From: Kate Giddings <kate.giddings@arun.gov.uk>
Sent: 13 October 2020 16:43
To: Amber Willard <Amber.Willard@arun.gov.uk>
Cc: Planning.Responses <Planning.Responses@arun.gov.uk>
Subject: FP/180/20/PD - 23a Felpham Road, Felpham, PO22 7DA

PROPOSED CONVERSION TO RESIDENTIAL
23a FELPHAM ROAD,
FELPHAM, WEST SUSSEX.

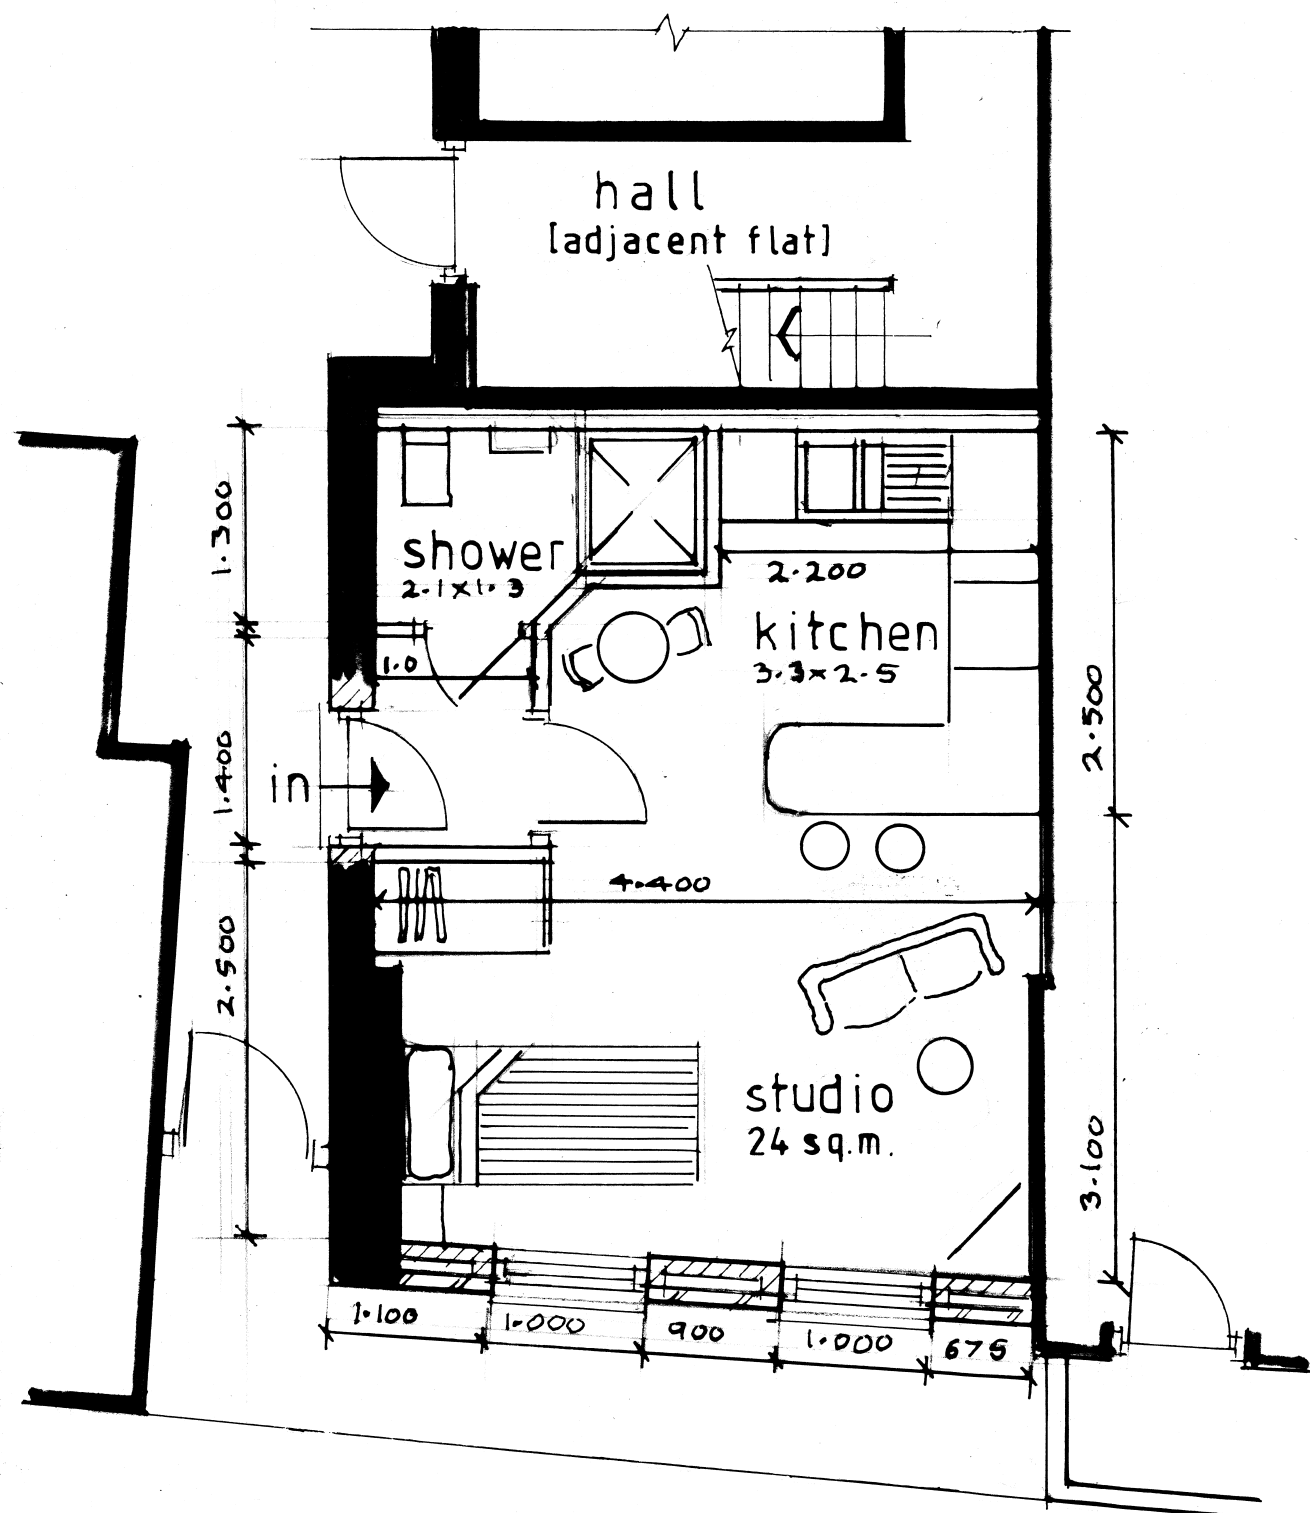
- The sound insulation of the walls between the subject property and the neighbouring residential unit shall achieve a minimum airborne sound insulation value of 48 dB ($D_{nT,w} + C_{tr}$). Prior to occupation of the proposed residential unit, a test to demonstrate compliance with this level shall be undertaken by a competent acoustician and submitted to and approved in writing by the Local Planning Authority. **Reason:** To protect the amenity of local residents in accordance with Policy QE SP1 of the Adopted Arun Local Plan 2011 – 2031

In addition to the above, please may the applicant advise where the extract system from the kitchen will be routed (including where it will terminate and any proposed outlet features, e.g. vents, baffles, cowls, etc.) and how any noise, vibration and odour emissions will be managed?
